Engineers Comments Regarding Surface Water Drainage

Application Reference:	Y/24/26/PL	Reviewer Reference:	ADC/ETX4b
Planning Officer:	Amber Willard	Date of Review:	04/06/2026
Site Name:	Sunnymead North End Road Yapton BN18 0DL		
Application Description:	Retention of fence at west of site on North End Road, hardstanding and access track and the creation of a residential caravan site with 3 No plots with associated parking, landscaping and facilities (resubmission following Y/57/24/PL). This application is a Departure from the Development Plan and is in CIL Zone 3 (Zero Rated) as other development.		
Assessment Number:	1 of 2

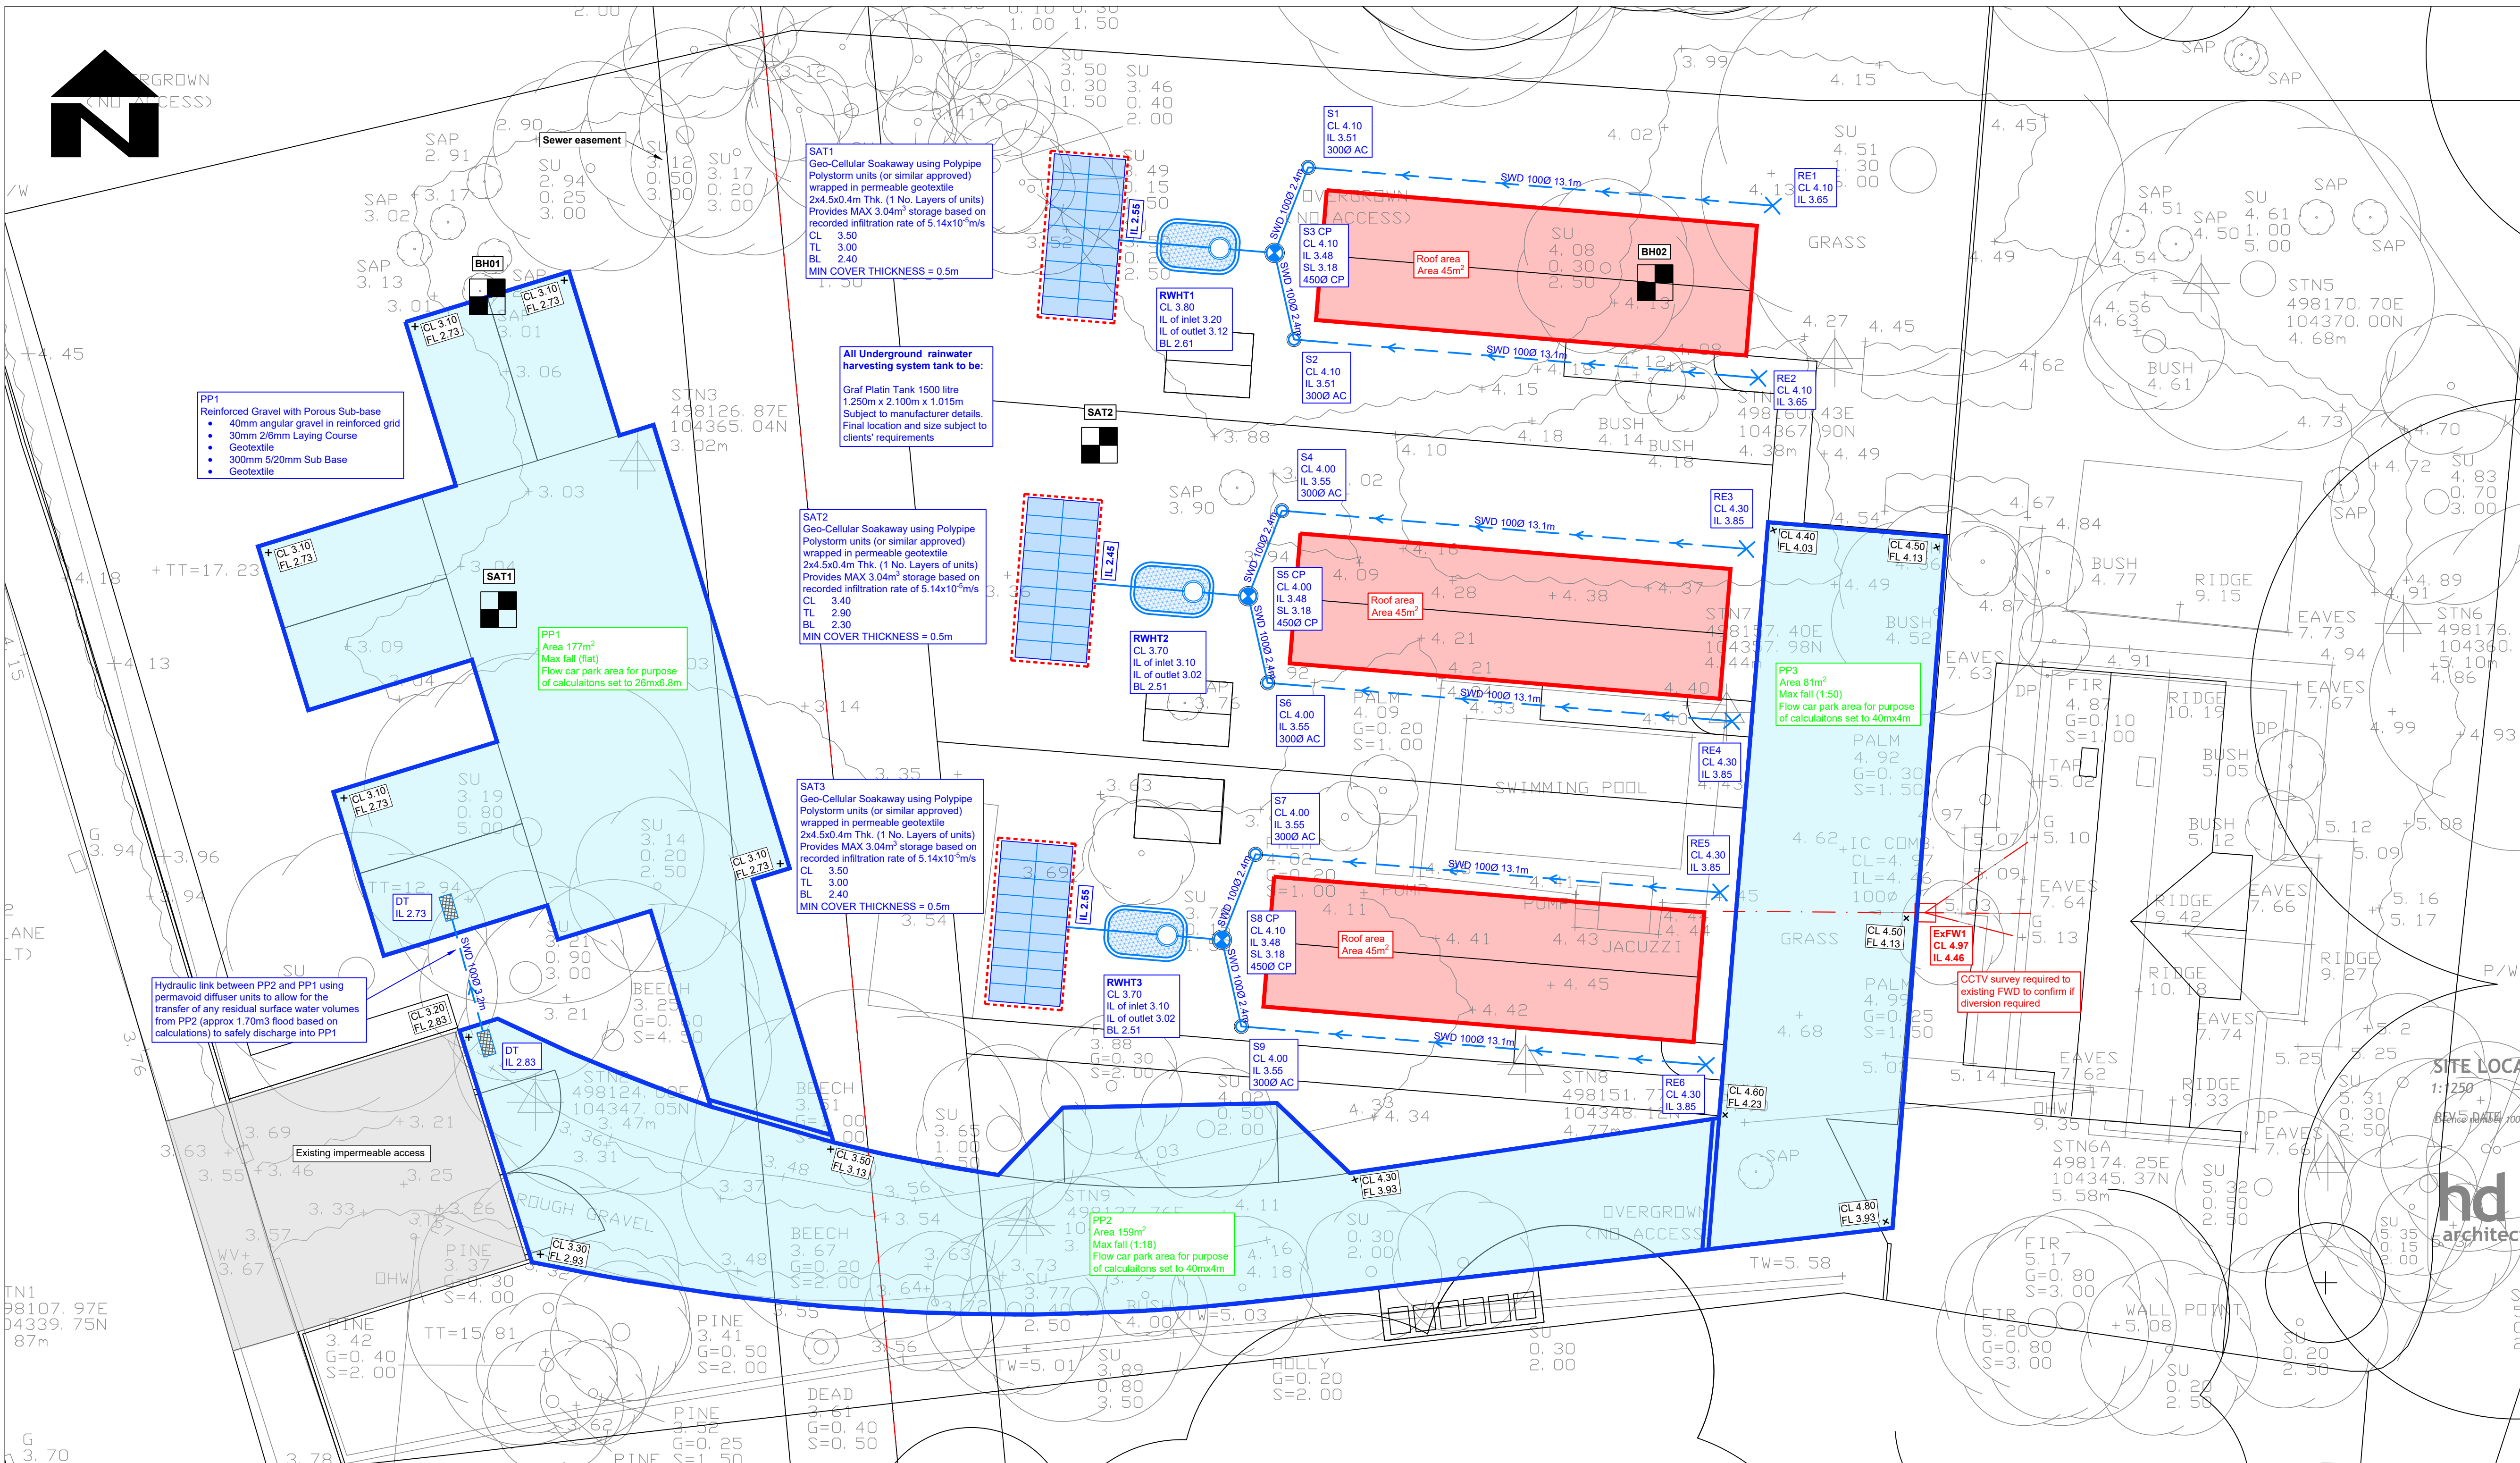
3.2. The proposed drainage strategy includes no reference to the surface water flood risk of the site and appears to position all storage features within areas of flood risk, despite parts of the site being at lower risk. By placing storage and infiltrating features in areas of flood risk there is an increased risk that features can be inundated by flood water prior to runoff entering them, rendering them ineffective and thus increasing flood risk.

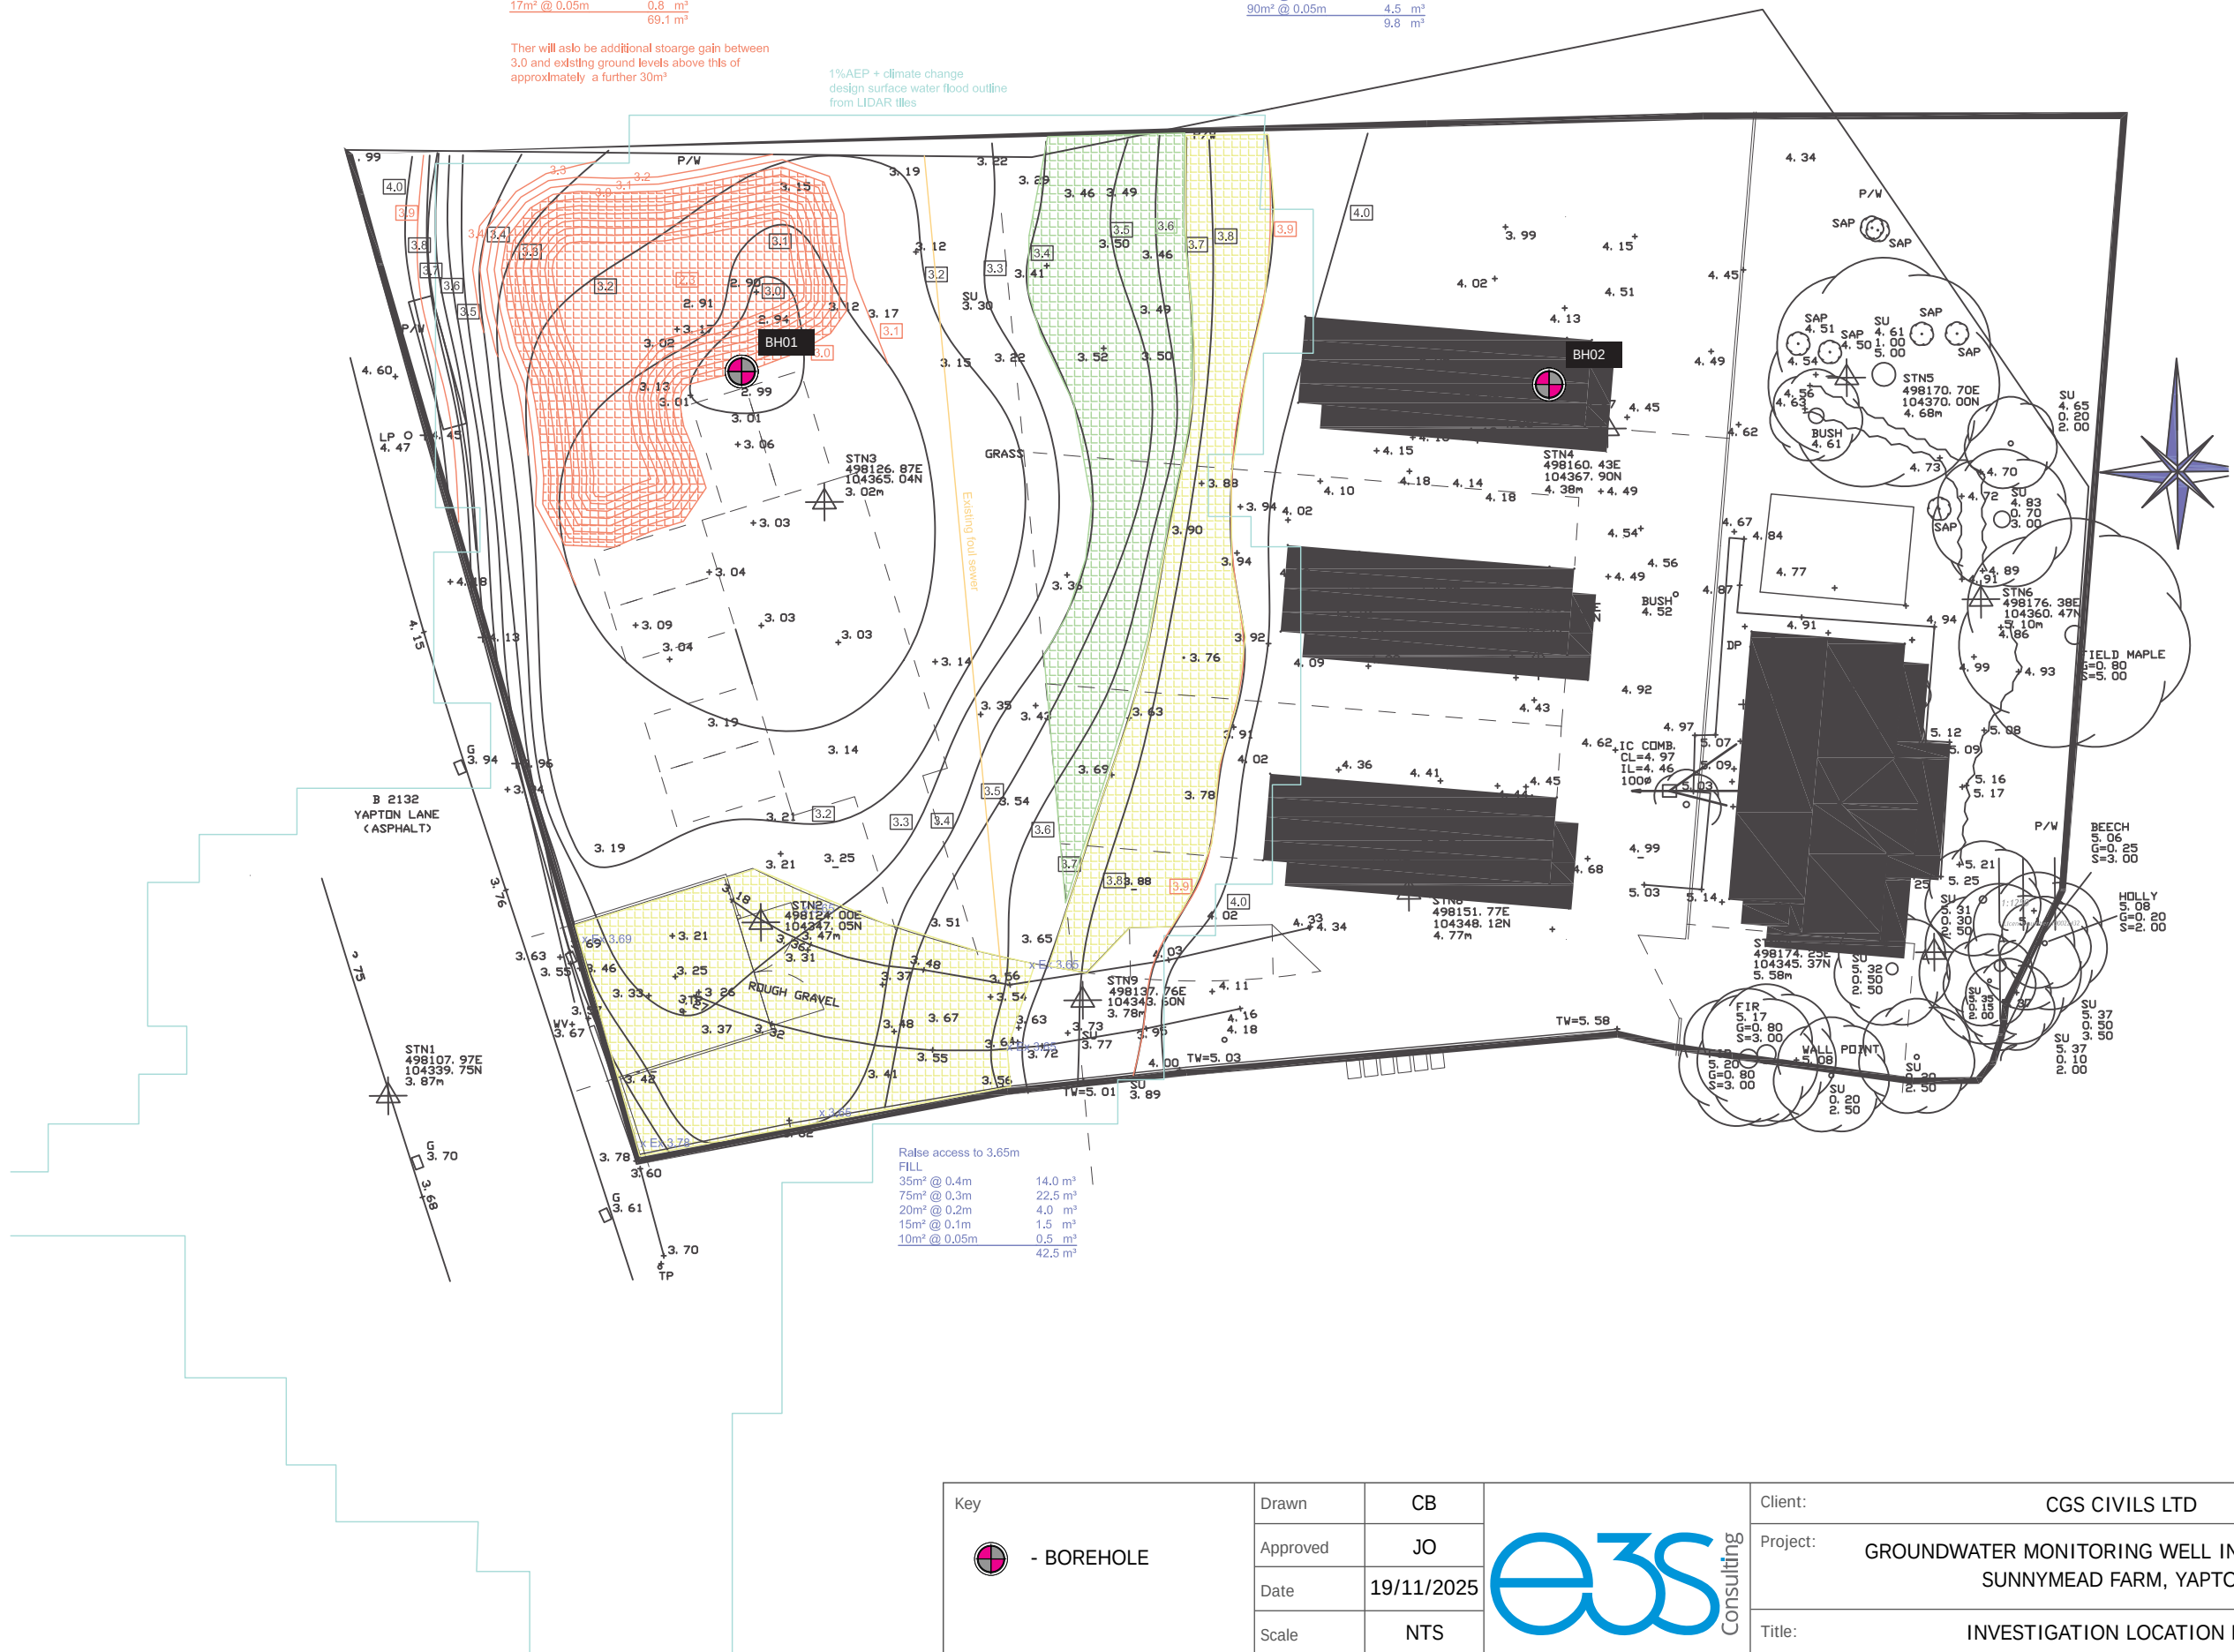
3.3. Furthermore, the proposed flood storage compensation plan does not follow the level-for-level and volume-for-volume method. As a result, a hydraulic connection between the highway and the applicant land is altered and flood risk will be increased.
